EL PASO COUNTY STORMWATER MANAGEMENT PLAN CHECKLIST

EPC Project Number: PPR2232

1"=40'  
INTERIM CONDITION DURING CONSTRUCTION TO BE CONVERTED TO SAND FILTER BASIN

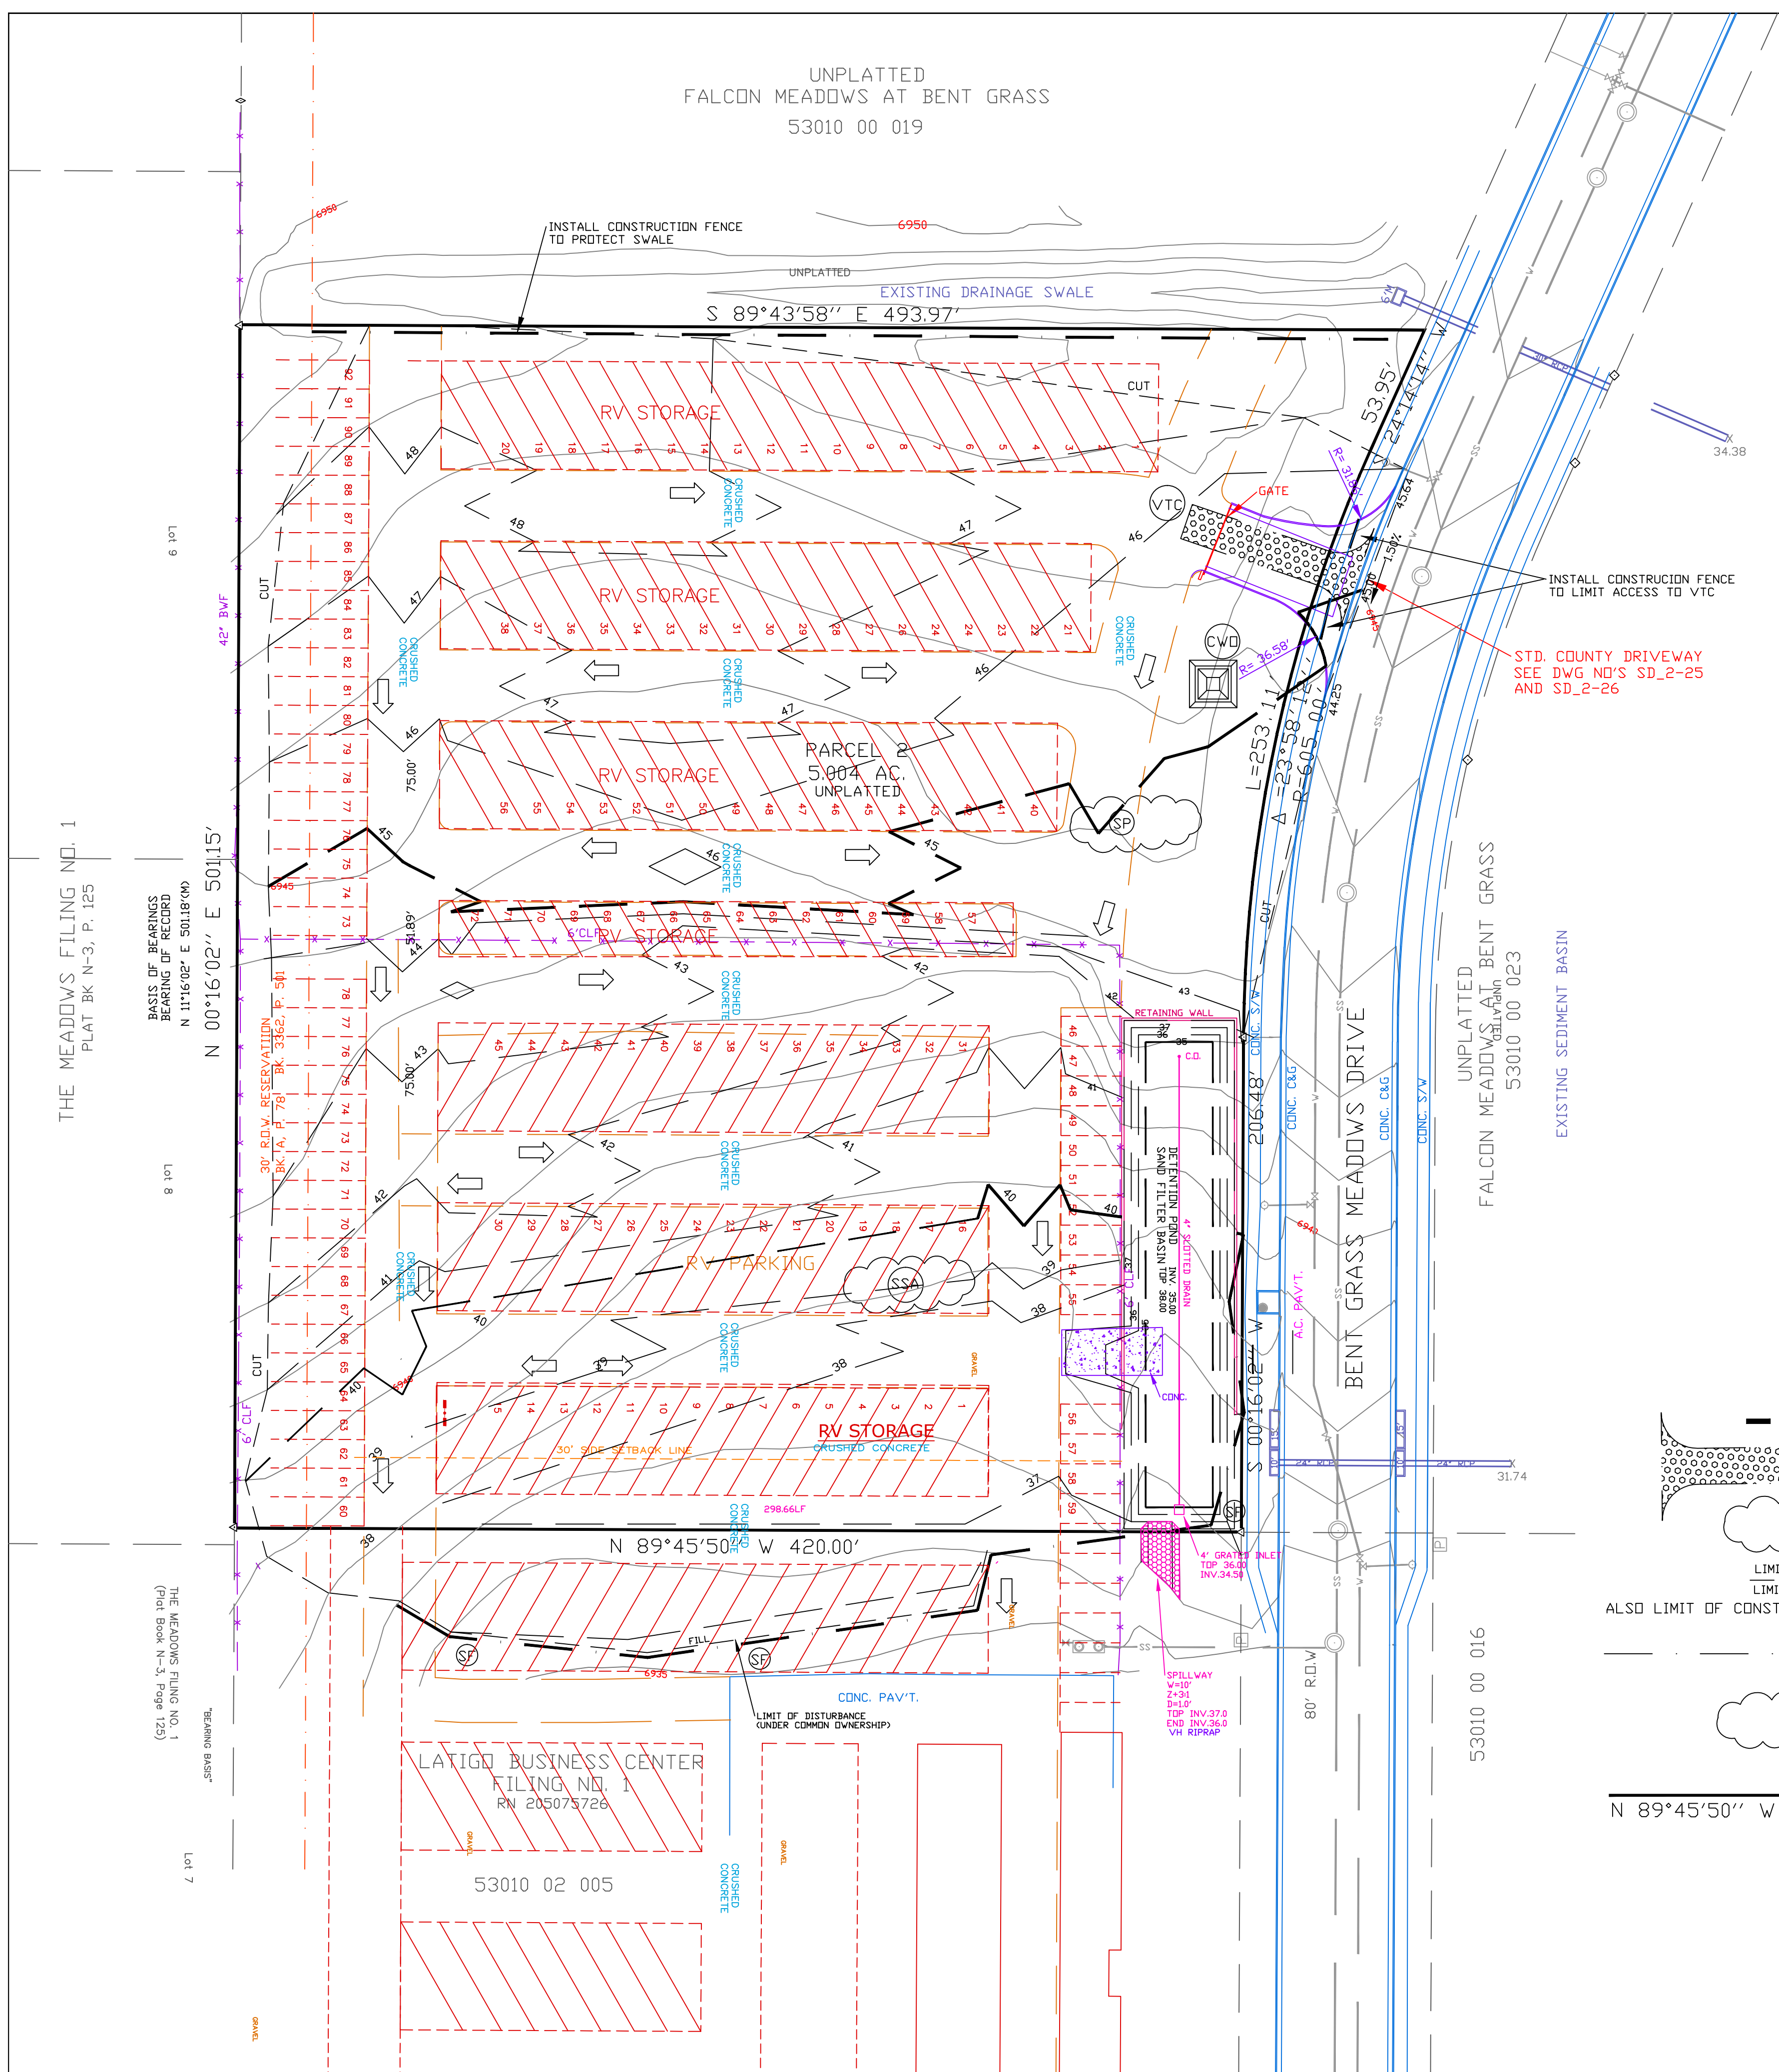
7	Estimates of the total site area and area to undergo disturbance; current area of disturbance must be updated on the SWMP as changes occur fix the typo on the SWMP		✗
8	Soil erosion potential and impacts on discharge that includes a summary of the data used to determine soil erosion potential		✓
9	A description of existing vegetation at the site and percent ground cover and method used to determine ground cover		✓
10	Location and description of all potential pollution sources including but not limited to: disturbed and stored soils; vehicle tracking; management of contaminated soils; loading and unloading operations; outdoor storage of materials; vehicle and equipment maintenance and fueling; significant dust generating process; routine maintenance activities involving fertilizers, pesticides, herbicides, detergents, fuels, solvents, oils, etc.; on-site waste management; concrete truck/equipment washing; dedicated asphalt, concrete batch plants and masonry mixing stations; non-industrial waste such as trash and portable toilets		✓

Applicant	EPC
17	SWMP Map to include: see GEC Plan for Items 17a - 17i		
17a	construction site boundaries needs revision/clarification		X
17b	flow arrows to depict stormwater flow directions		X
17c	all areas of disturbance		X
17d	areas of cut and fill needs revision/clarification		X
17e	areas used for storage of building materials, soils (stockpiles) or wastes		✓
17f	location of any dedicated asphalt / concrete batch plants		X
17g	location of all structural control measures		X
17h	location of all non-structural control measures		X
17i	springs, streams, wetlands and other surface waters, including areas that require maintenance of pre-existing vegetation within 50 feet of a receiving water		X
18	Narrative description of all structural control measures to be used. Modifications to EPC standard control measures must meet or exceed County-approved details		X
19	Description of all non-structural control measures to be used including seeding, mulching, protection of existing vegetation, site watering, sod placement, etc.		✓

20	Technical drawing details for all control measure installation and maintenance; custom or other jurisdiction's details used must meet or exceed EPC standards see GEC		X
21	Procedure describing how the SWMP is to be revised		✓
22	Description of Final Stabilization and Long-term Stormwater Quality (describe nonstructural and structural measures to control SW pollutants after construction operations have been completed, including detention, water quality control measure etc.)		X
23	Specification that final vegetative cover density is to be 70% of pre-disturbed levels		✓
24	Outline of permit holder inspection procedures to install, maintain, and effectively operate control measures to manage erosion and sediment		X
25	Record keeping procedures identified to include signature on inspection logs and location of SWMP records on-site		
26	If this project relies on control measures owned or operated by another entity, a documented agreement must be included in the SWMP that identifies location, installation and design specifications, and maintenance requirements and responsibility of the control measure(s)		X
